Re: Case Number ABP-318802-24

In response to your letter of 30 September 2026, we are happy to provide you with the requested further information in relation to the proposed development.

Attachment 1: Amended Planning Boundary: Drawing Number 1434-104_14 Oct 2026

Drawing file: Further Information - October 2026 / Attachment 1 IE_Cork_Planning_1434-104_14.pdf

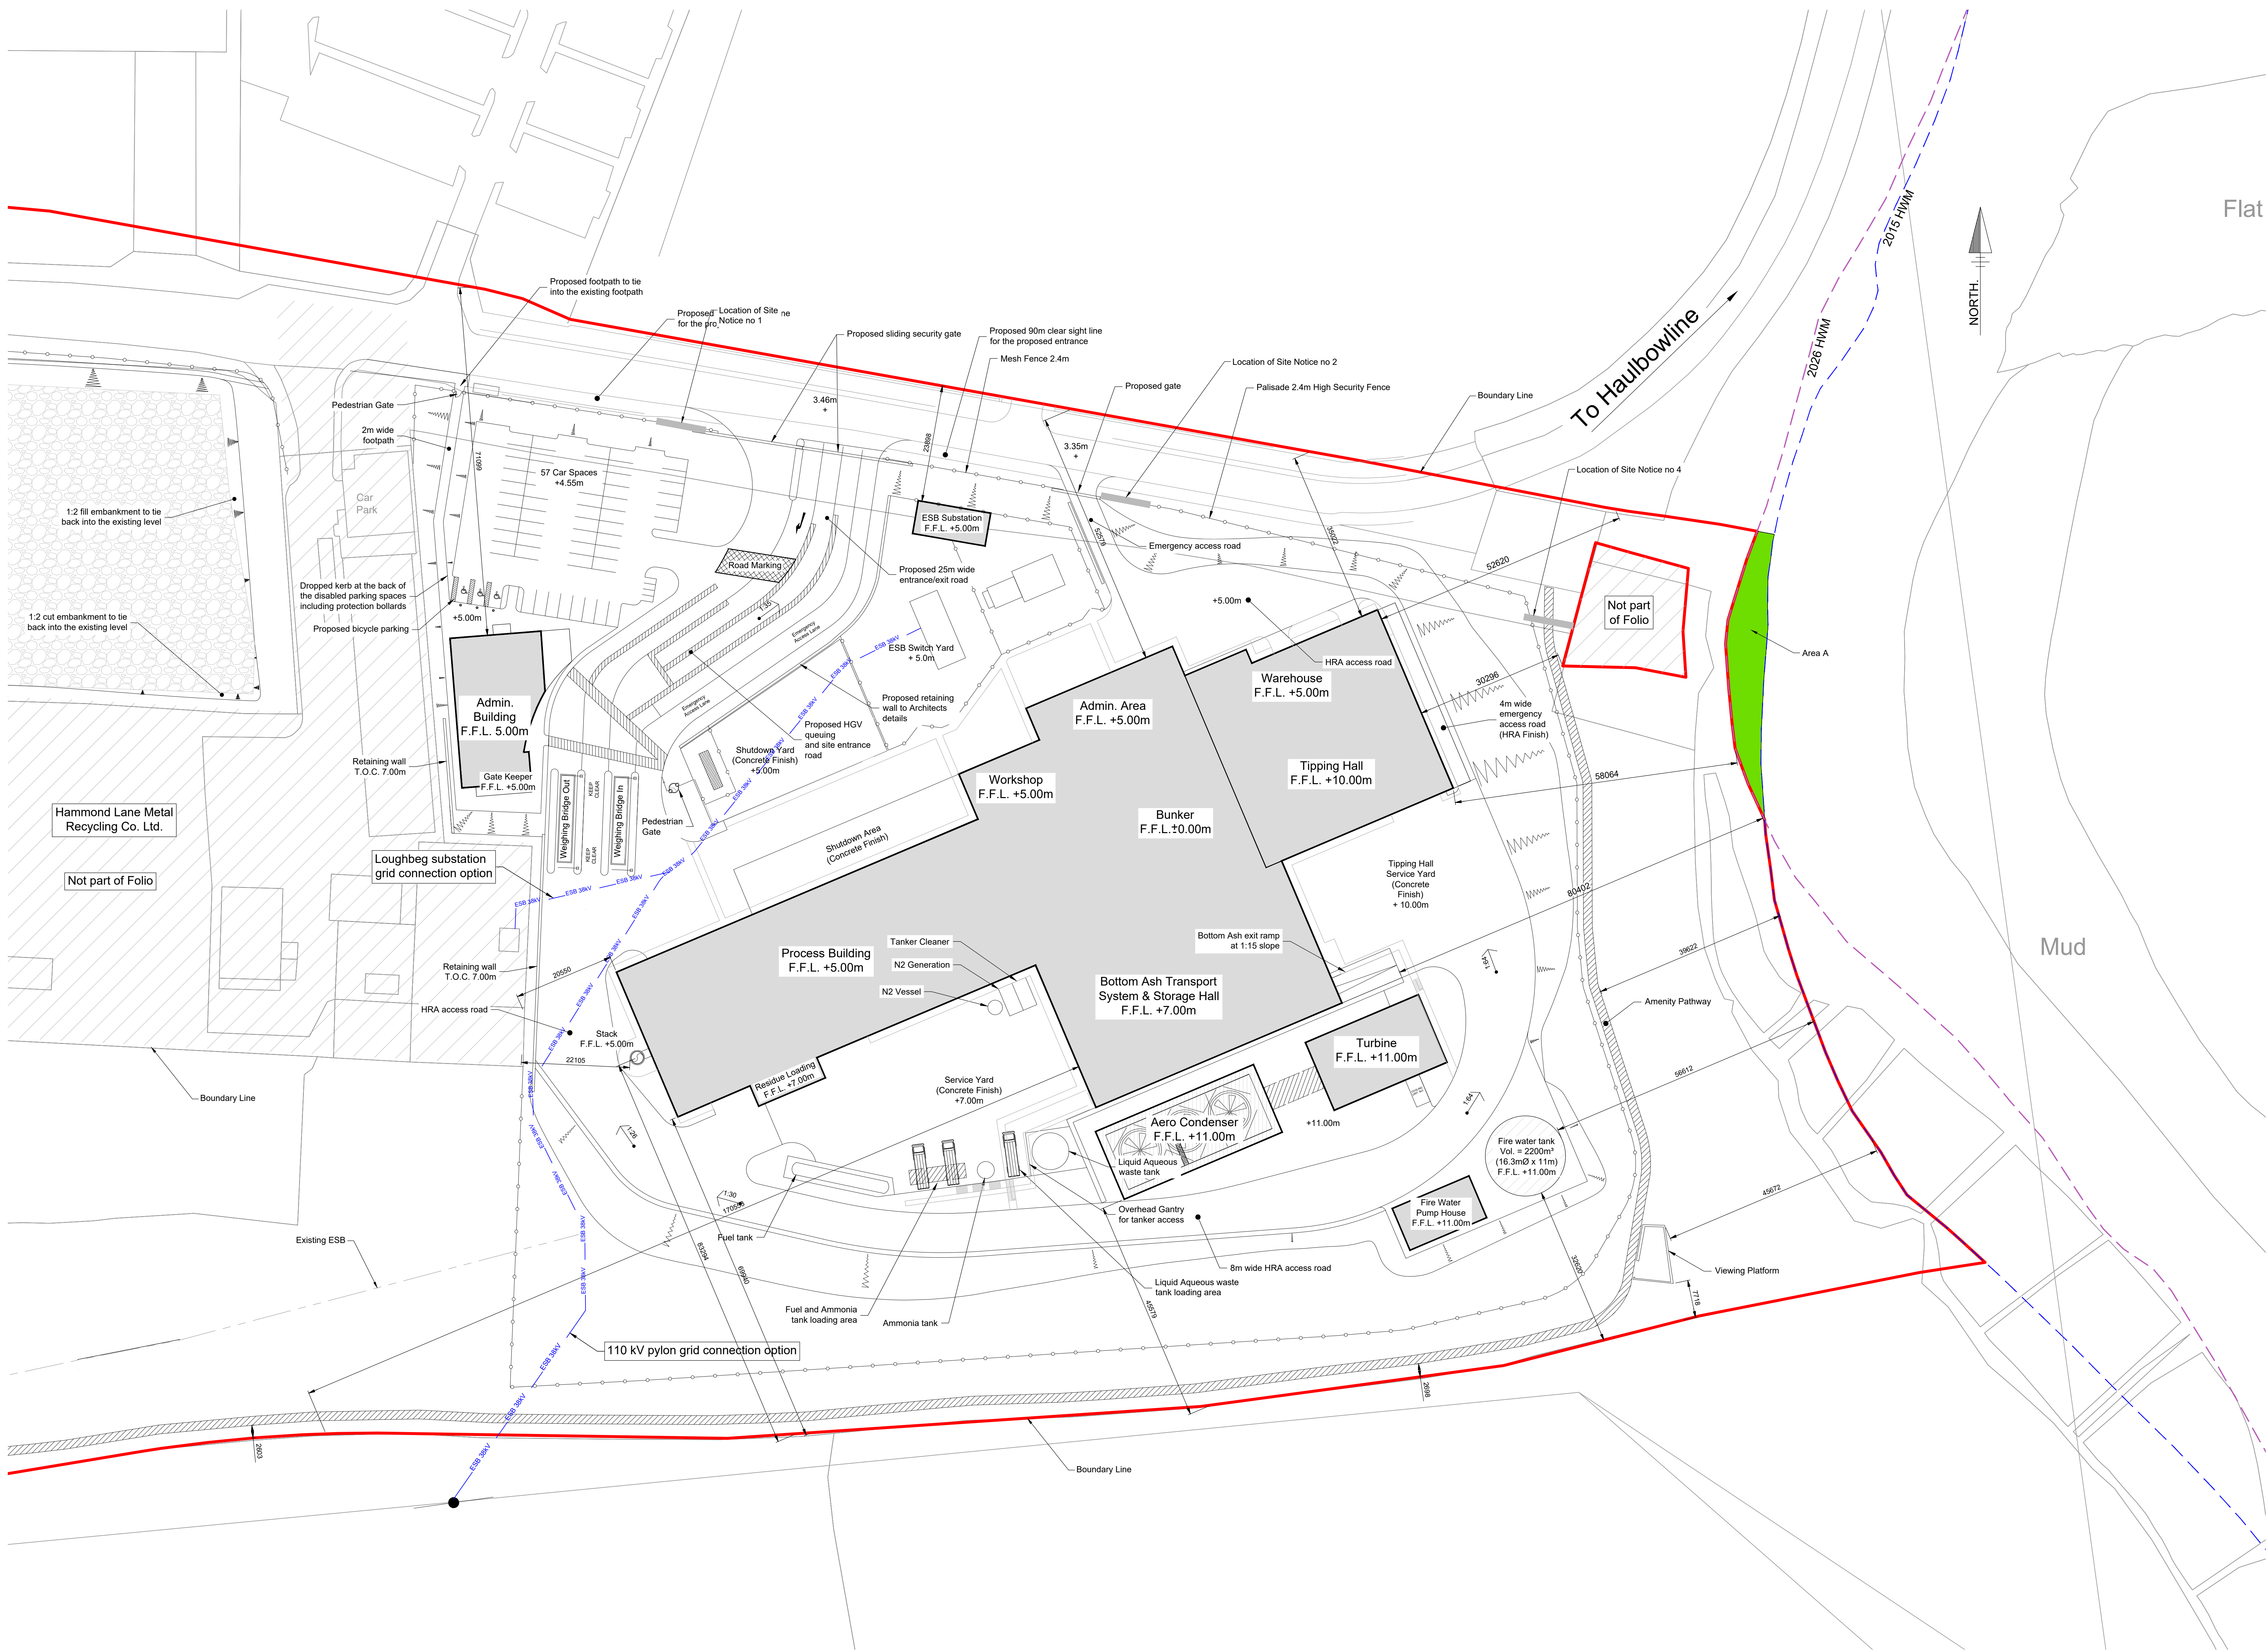
- (i) *additional information (including drawings) that demonstrate the current delineated high water mark and its relationship to both the application site (red line) boundary and the high water mark identified on the application documentation*

(ii) *the implications of any change in the high water mark for (I) land ownership, (II) development boundaries, and (III) the applicable statutory consenting regime including clarification of any requirement for consent, licence, or other authorisation under the Maritime Area Planning Act 2021.*

See enclosed drawing number IE_Cork_Planning_1434-104_14 which shows both the 2026 HWM

(marked with a purple line) and the high-water mark identified on the application documentation (“**2015 HWM**”) (marked with a blue line).

Where there is a difference between the 2015 HWM and the 2026 HWM, the parcel of land the status of which has changed (i.e., to being above or below the HWM) is shaded in green and labelled ‘A’ in the enclosed drawing IE_Cork_Planning_1434-104_14.

Accordingly, Indaver submits that the redline boundary for the application should be amended as per drawing IE_Cork_Planning_1434-104_14 enclosed.
